Single storey side/rear extension, part two storey rear extension rear extension, raising of roof height to create a second floor and front double garage.

56 Angmering Lane East Preston Littlehampton

*Planning application - EP/37/20/HH
56 Angmering Lane, East Preston*

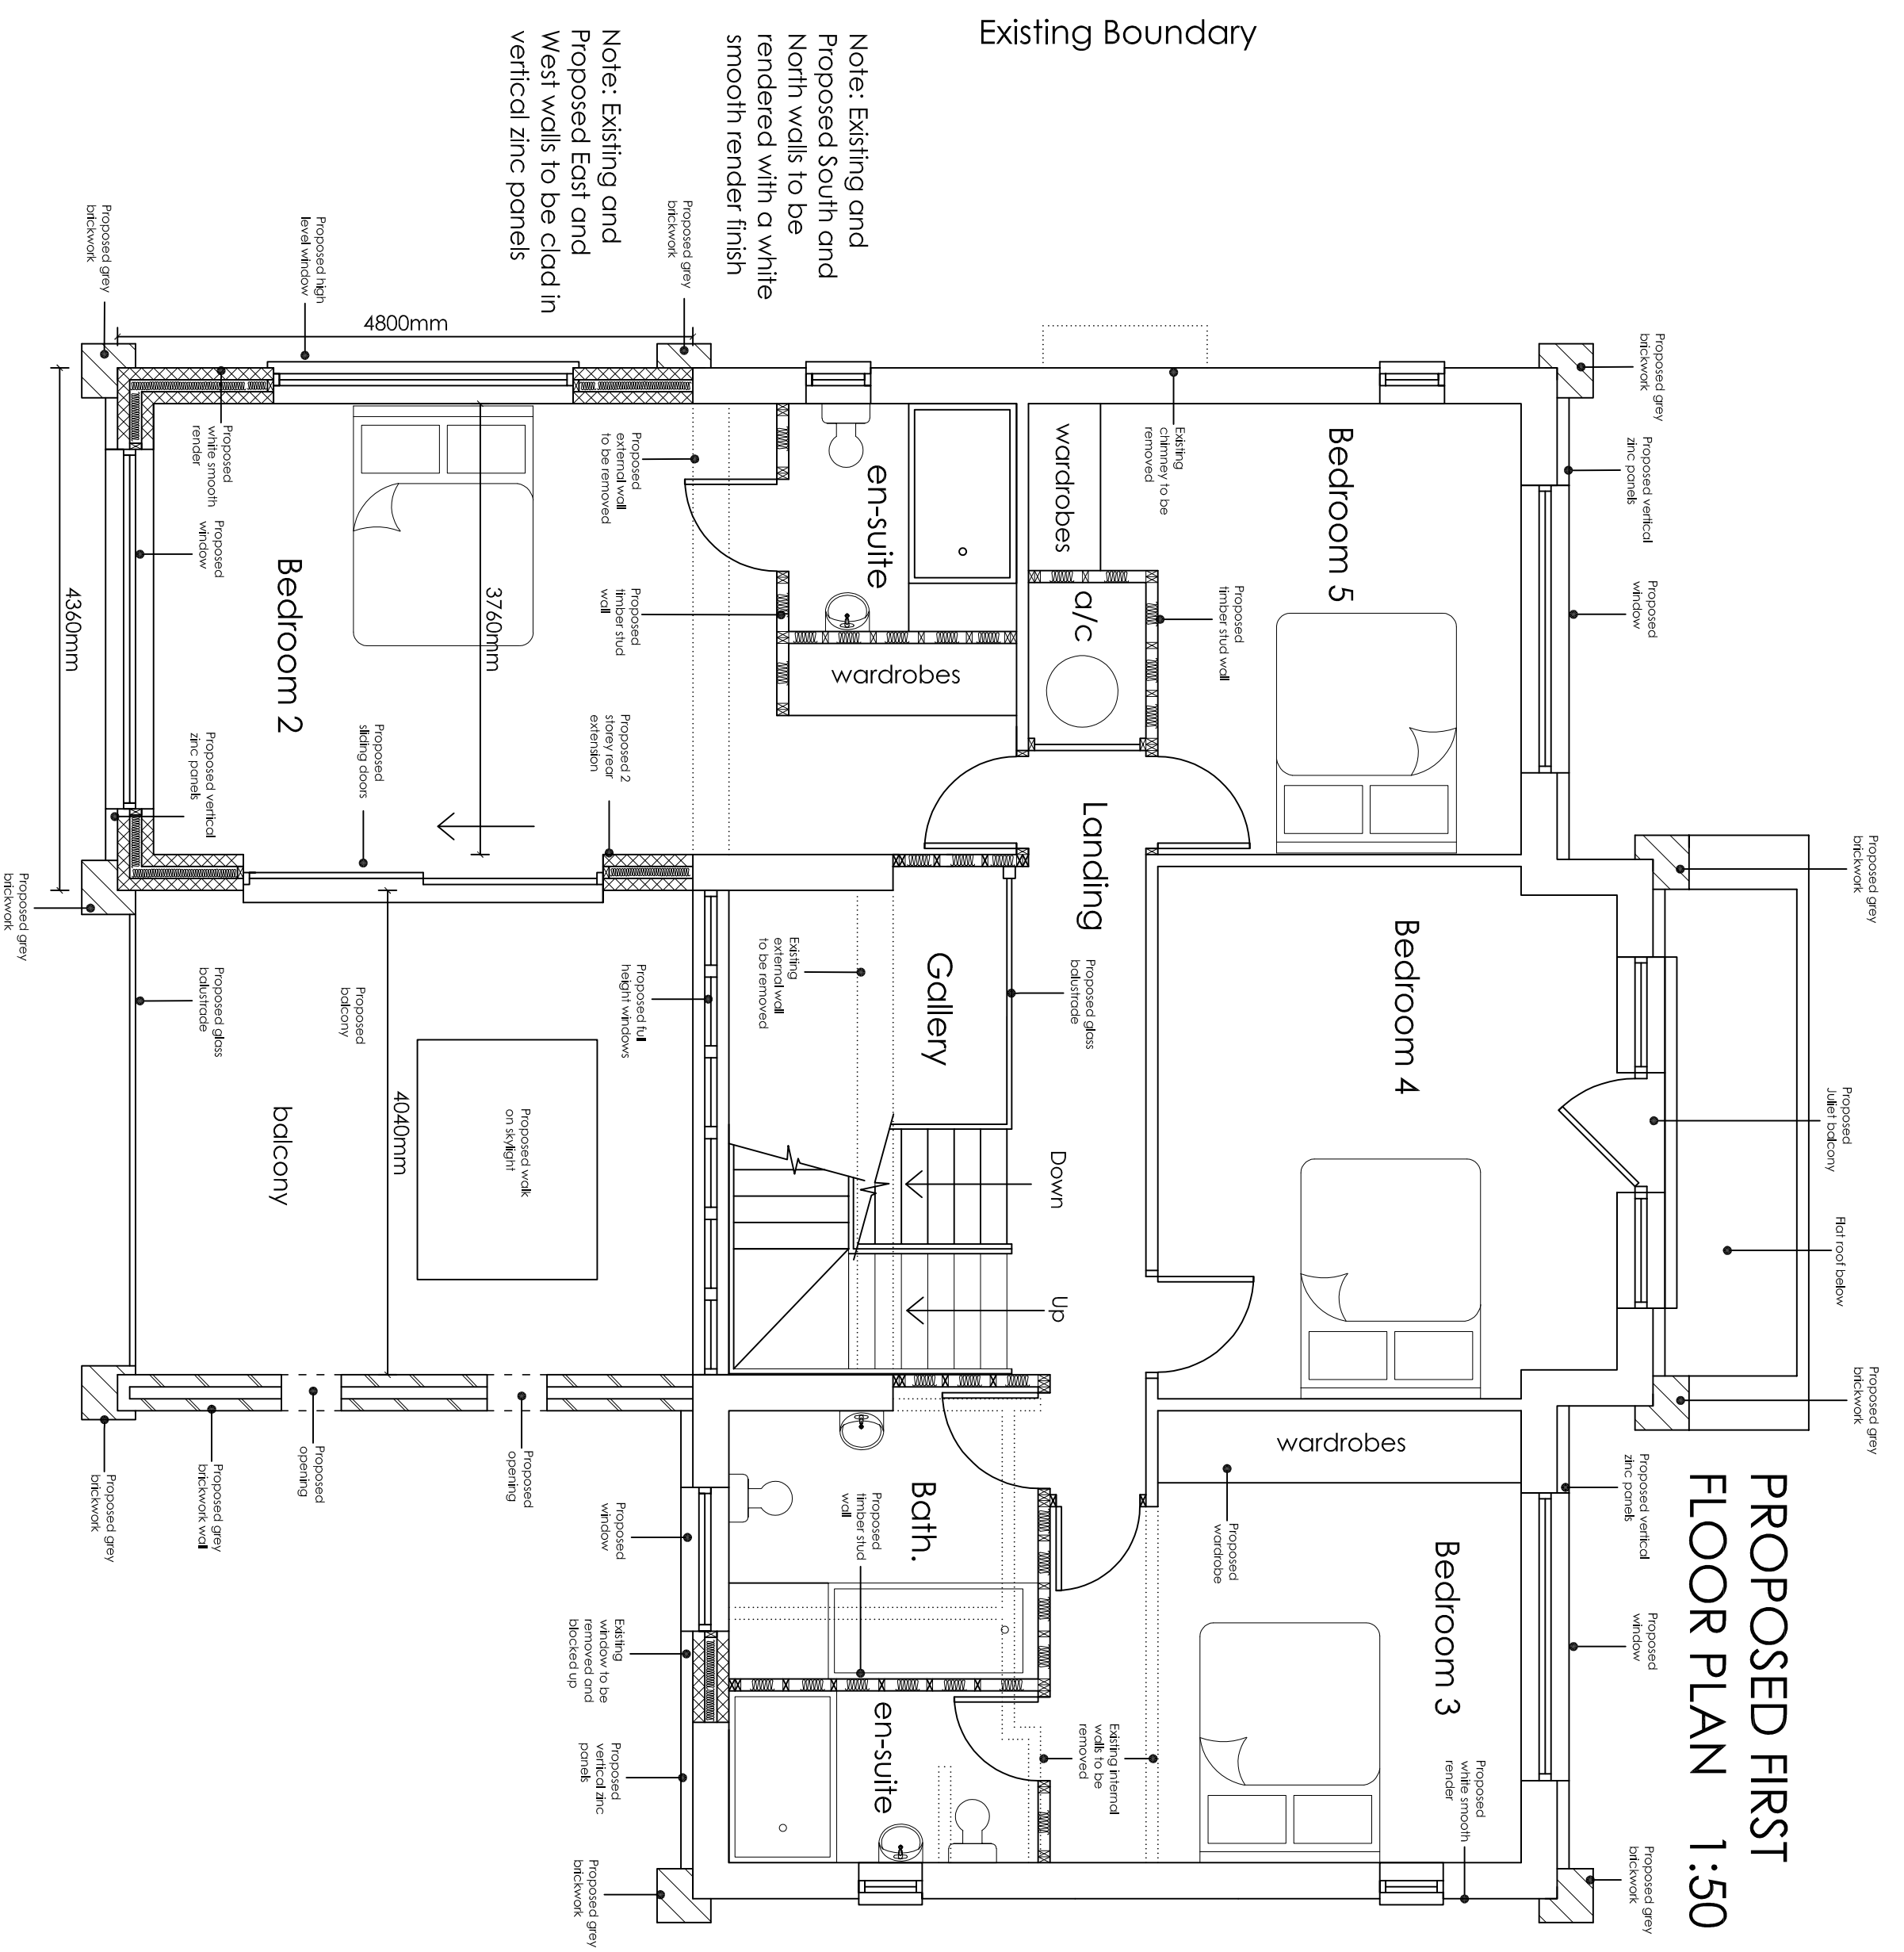
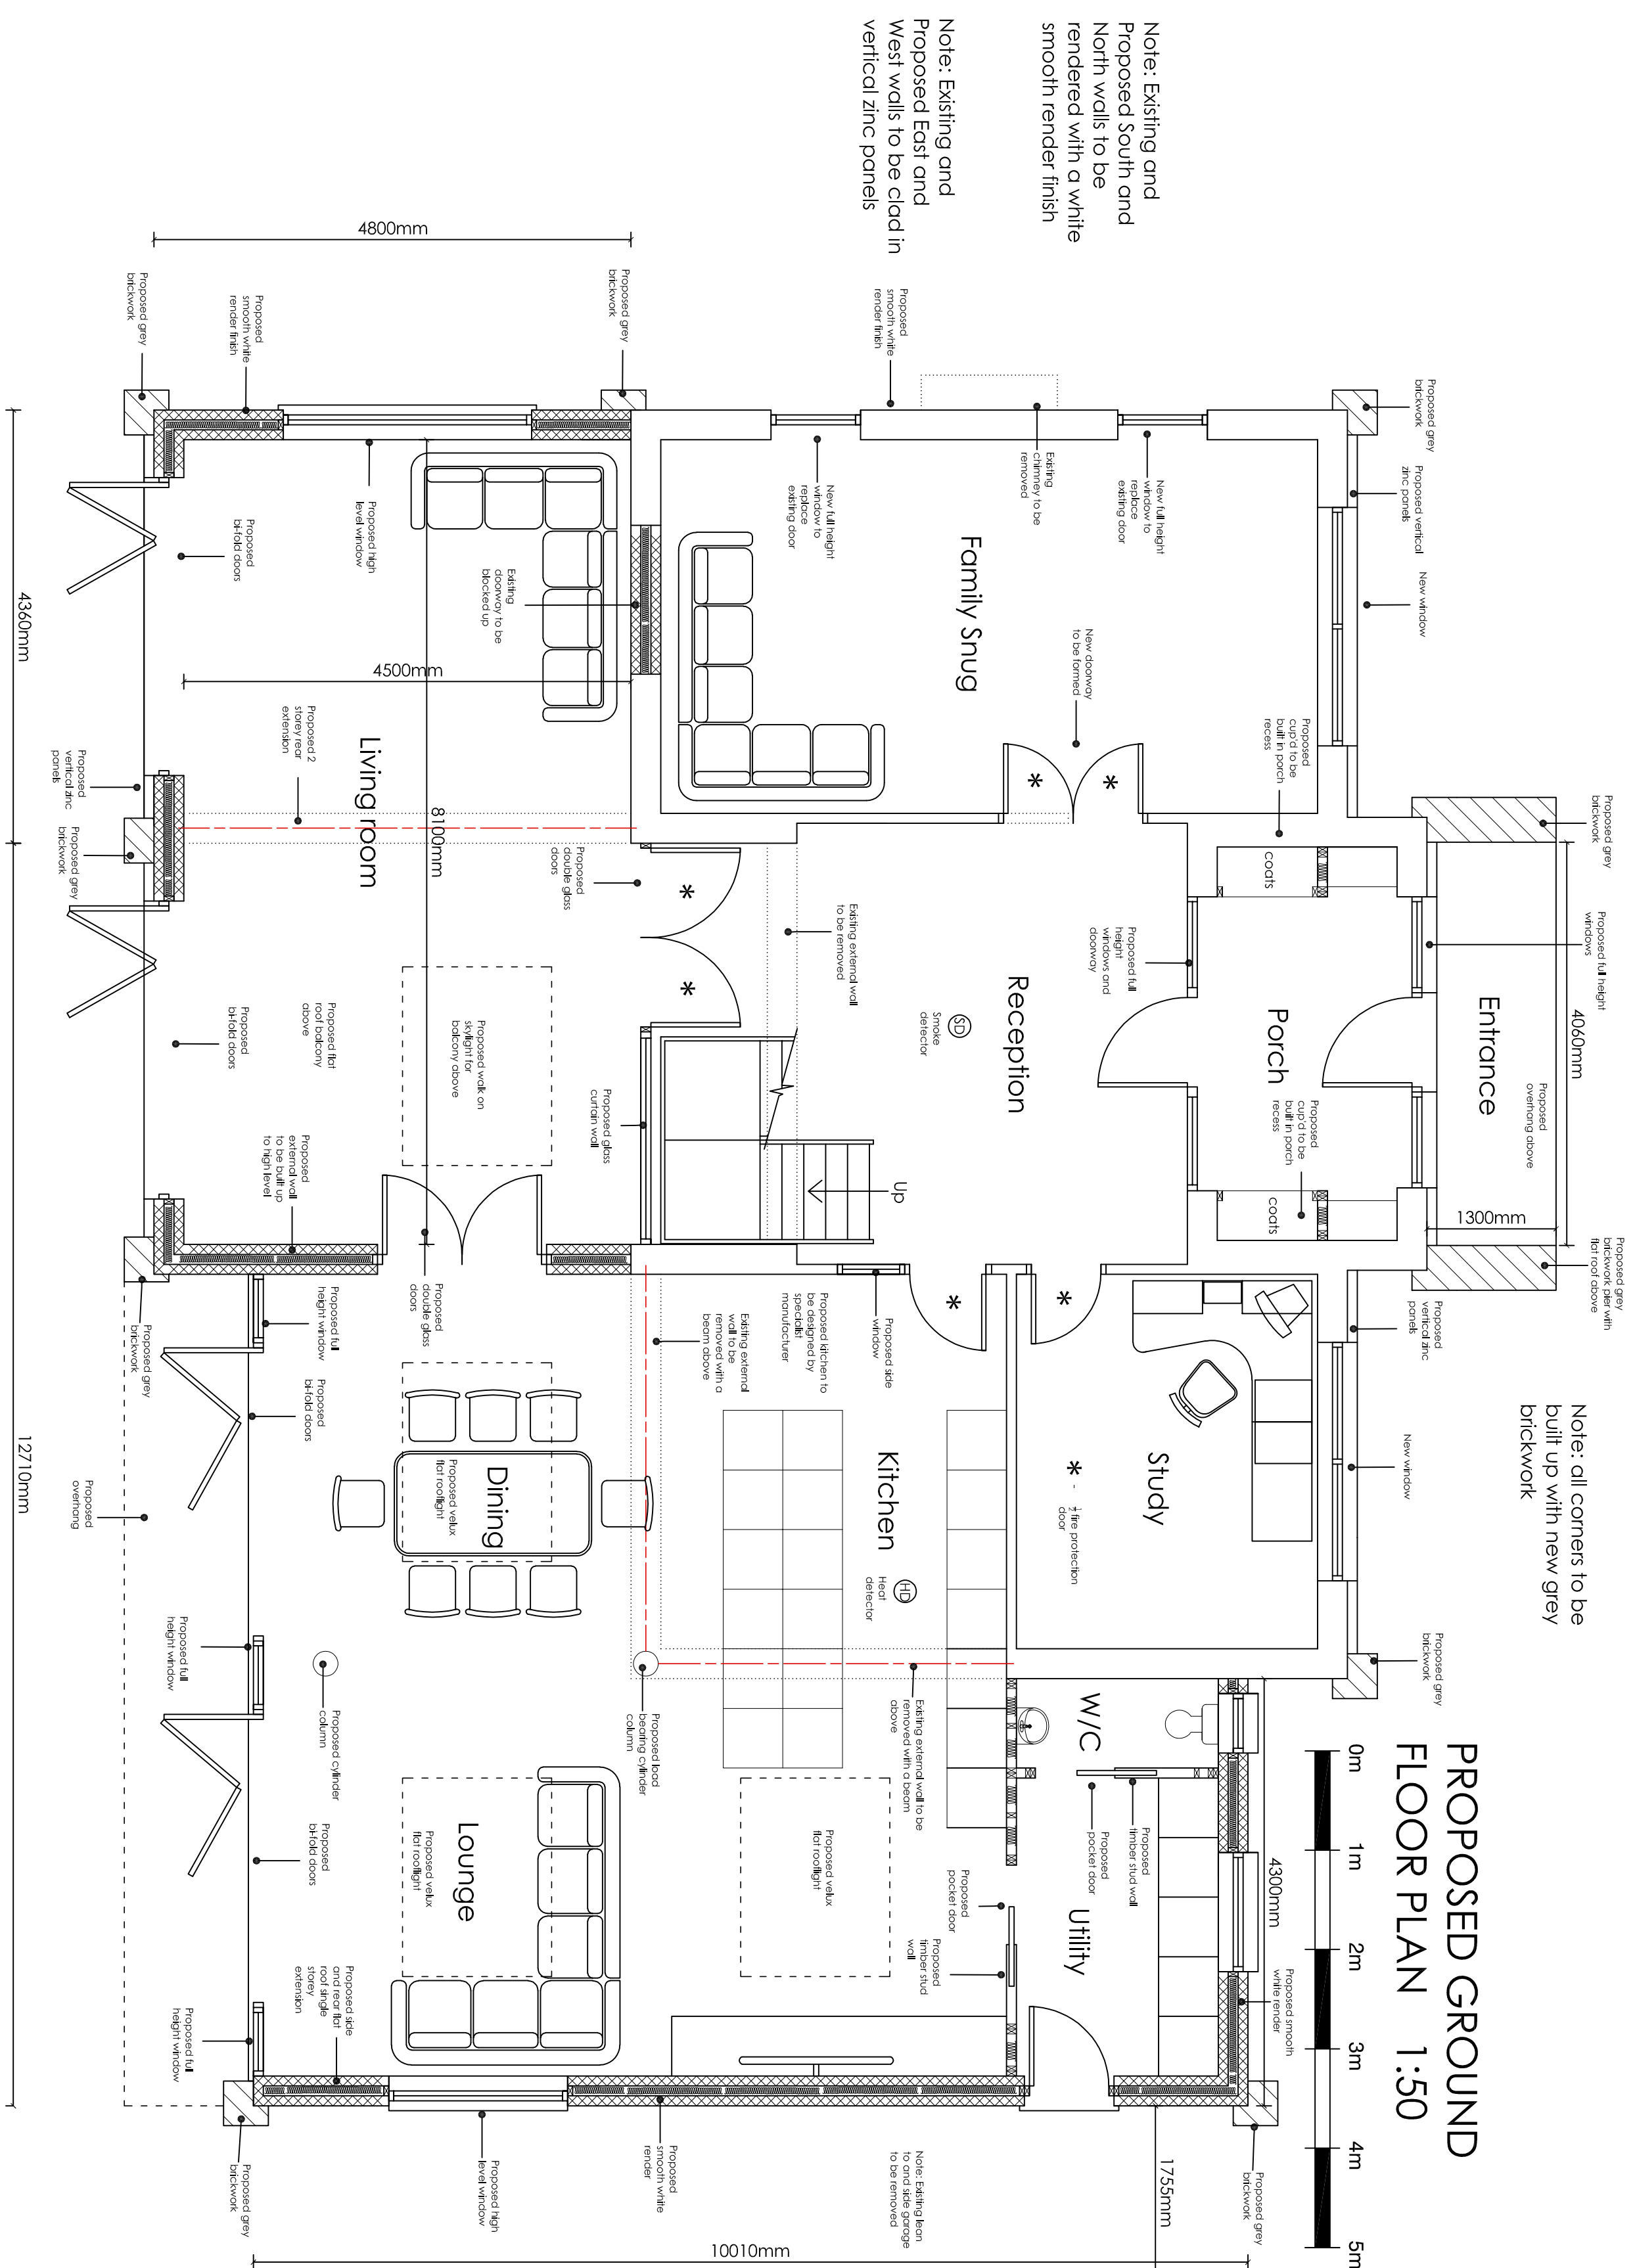
By changing from a traditional pitched roof style with two storeys to a three-storey flat-roofed property, they would in effect be creating something that resembles a small block of flats, which would be out of character with the remainder of the estate. In addition, the windows on the upper storey would overlook our house and garden, thereby directly impacting on our privacy and that of our other neighbours.

The plans also show that the garage would be much closer to the road than any buildings on the adjacent properties, which would detract from the general visual integrity of the street. The overall impression from the road is of houses set well back, within their own grounds and the current application would negate this.

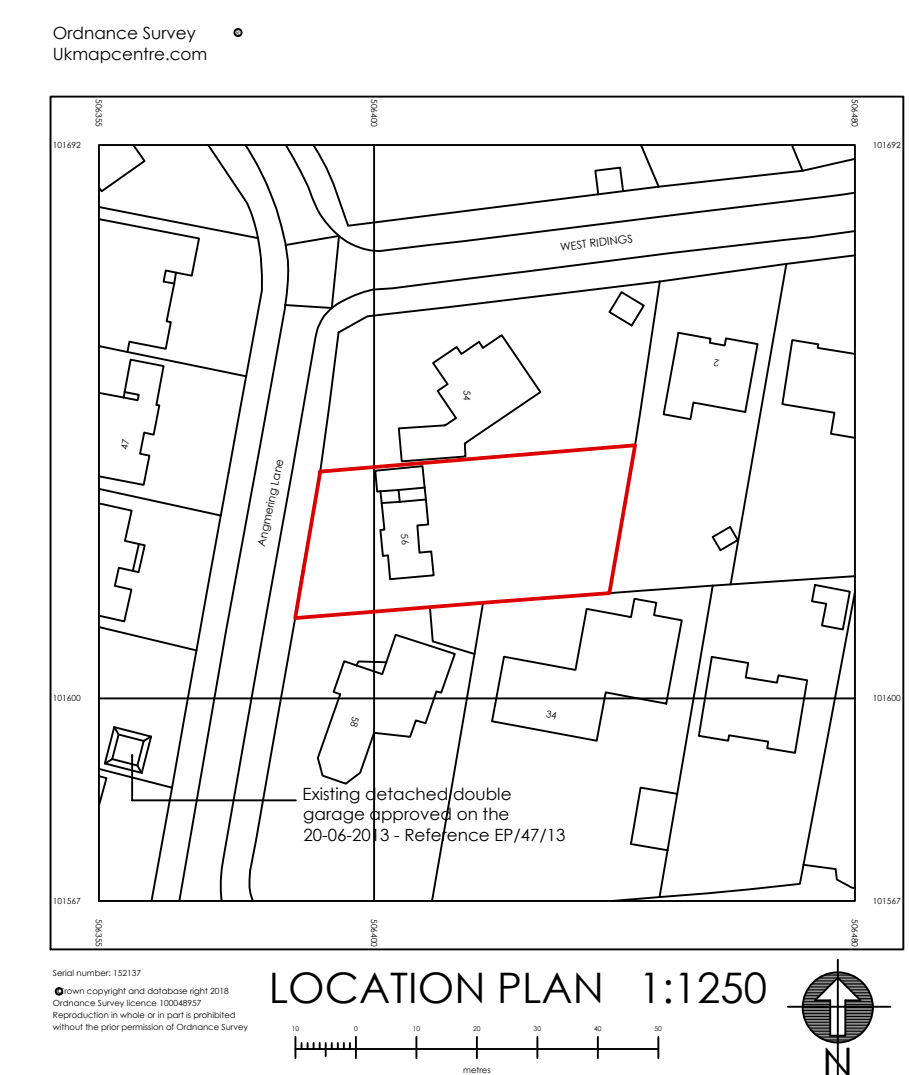
In addition, the amendment to the layout of the building has the effect of more than doubling its floor space and is there a substantial change in the character of the property.
